**From:** Elenya Jackson  
**Sent:** 02 July 2025 09:37  
**To:** DC Admin  
**Subject:** FW: Planning application 2025/N/91175/E

**From:**  
**Sent:** 15 May 2025 20:56  
**To:** Elenya Jackson <Elenya.Jackson@kirklees.gov.uk>; Mathias Franklin <Mathias.Franklin@kirklees.gov.uk>  
**Subject:** Planning application 2025/N/91175/E

I am writing to formally appeal the approval of planning application 2025/N/91175/E submitted by John Dodson for the following reasons:

Drawing Title.
**SITE PLAN AS
EXISTING**

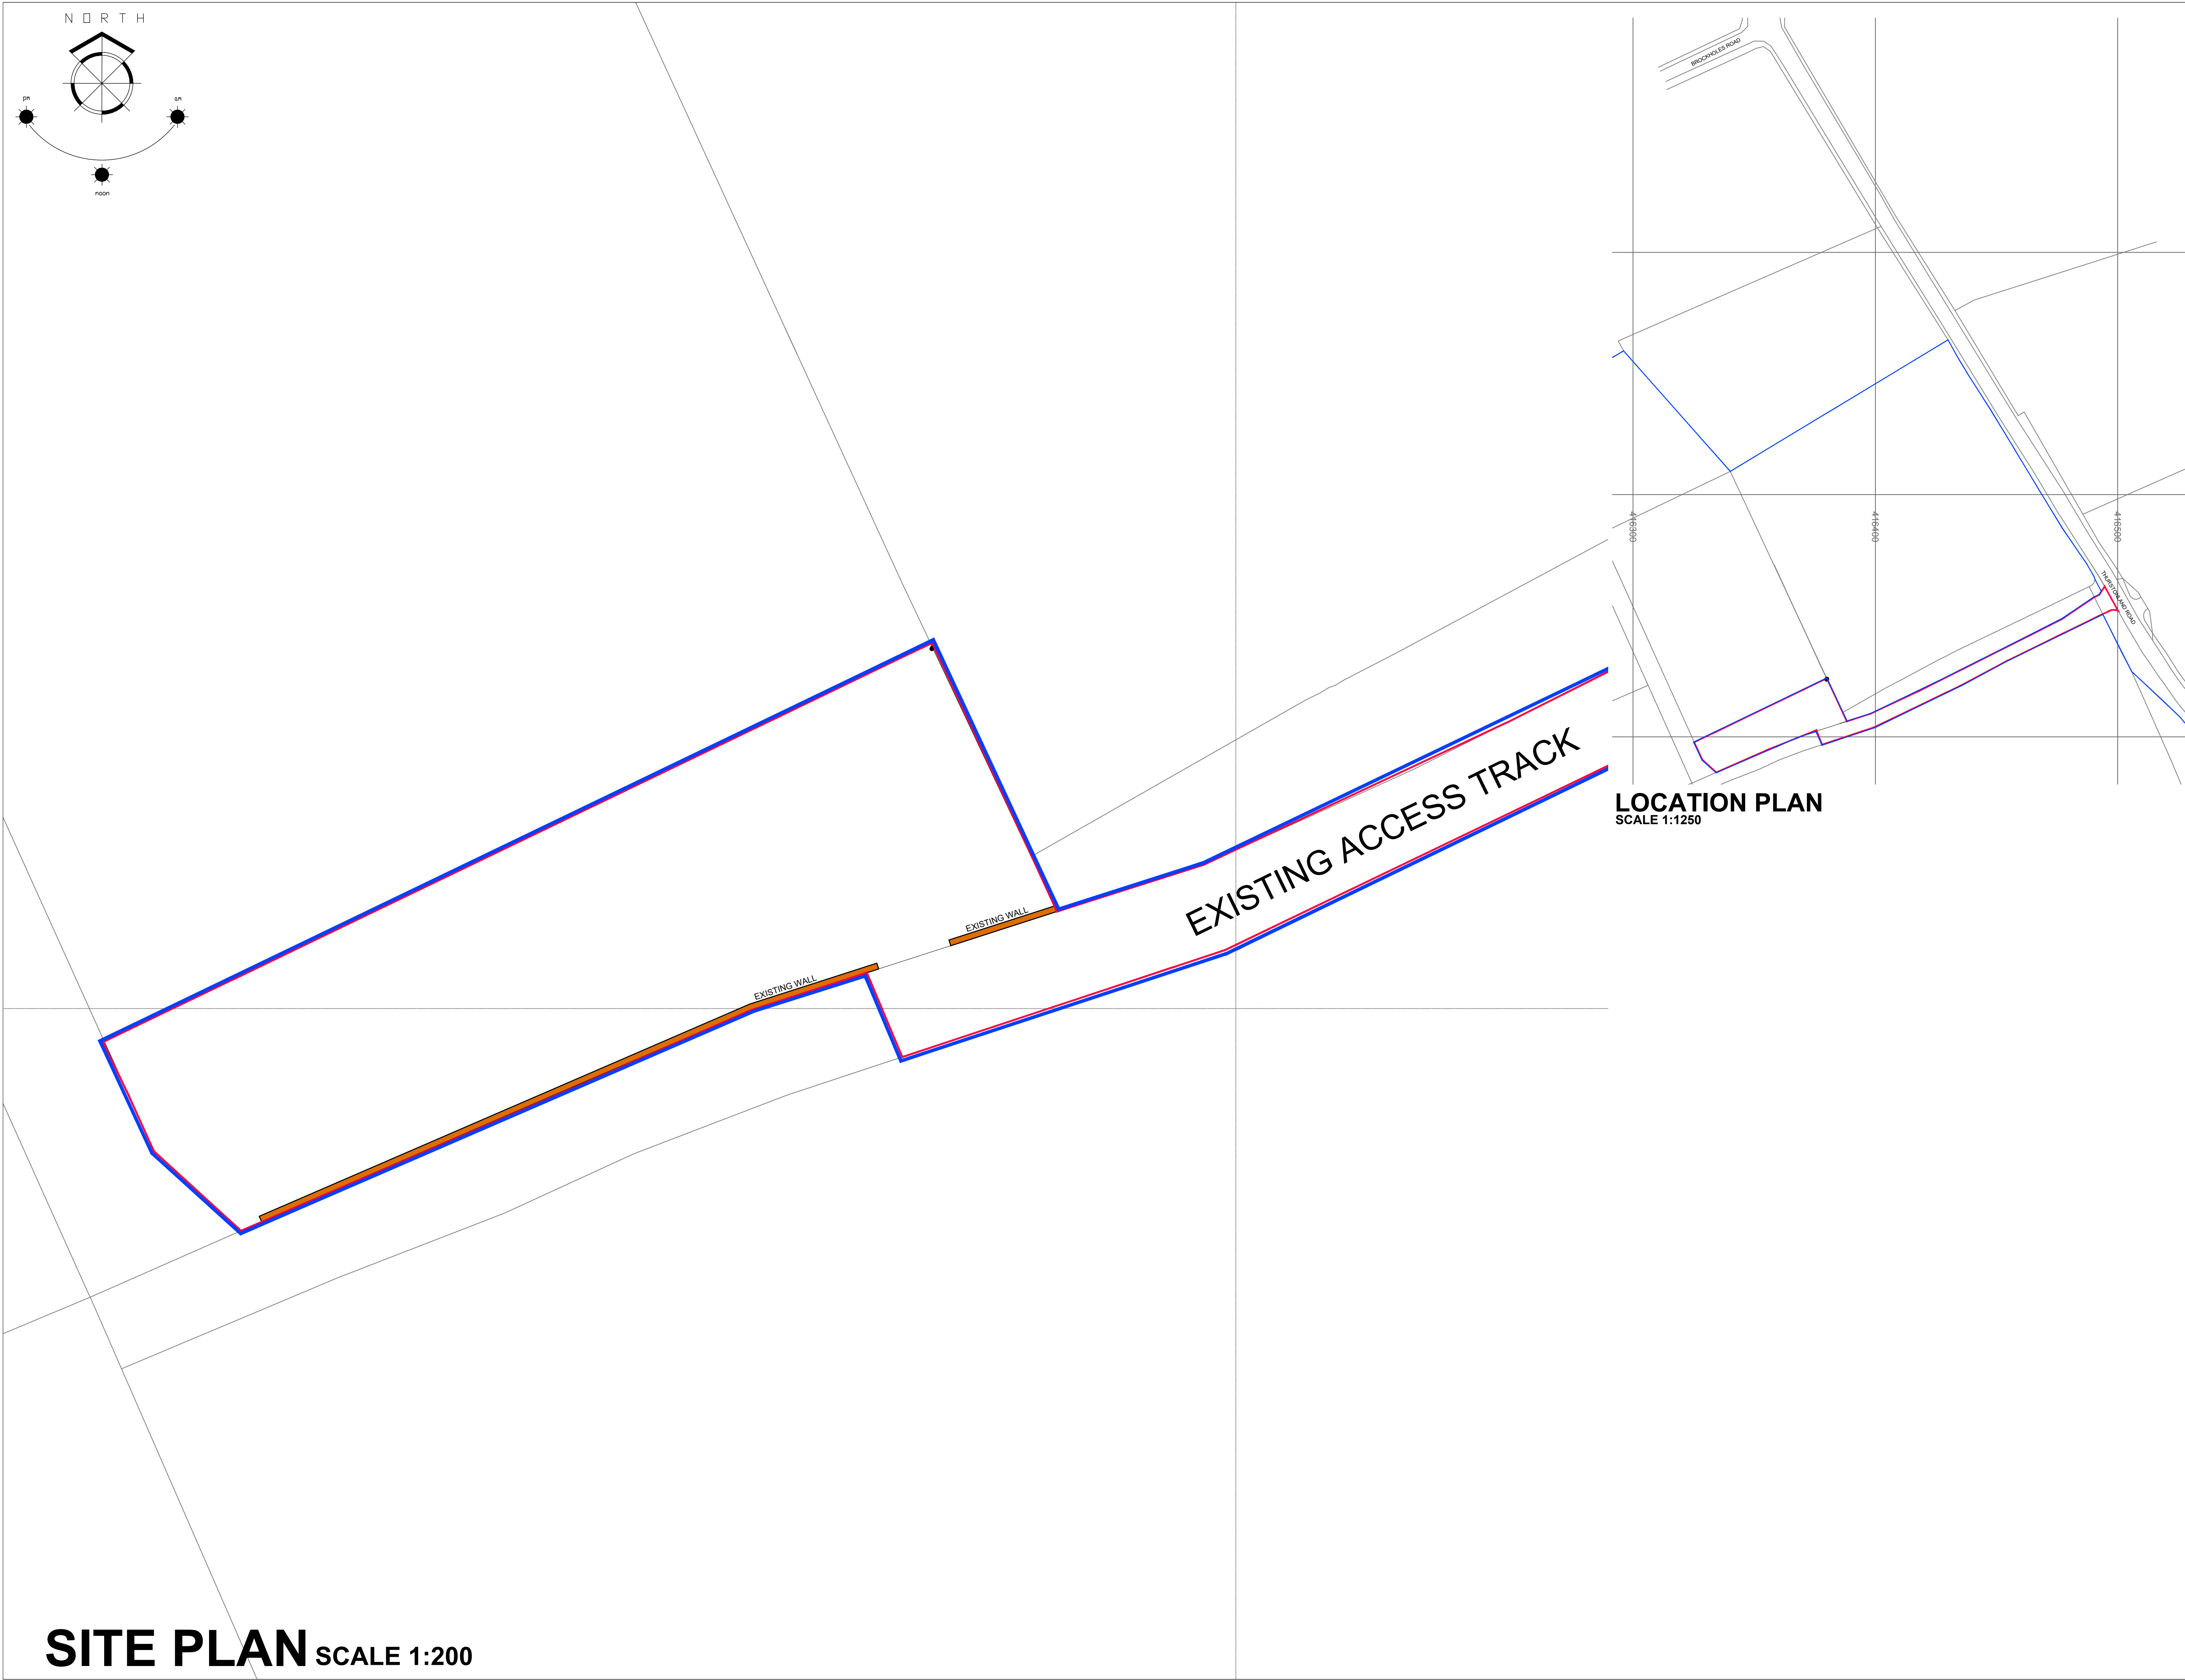
The application itself is for a permanent change of use and changed frequency of use. I am not convinced that Mr Dodson does much in the way of active farming, so question his need of this access and storage area for bales of hay which from what I can work out, on the plans submitted will be part of this track.
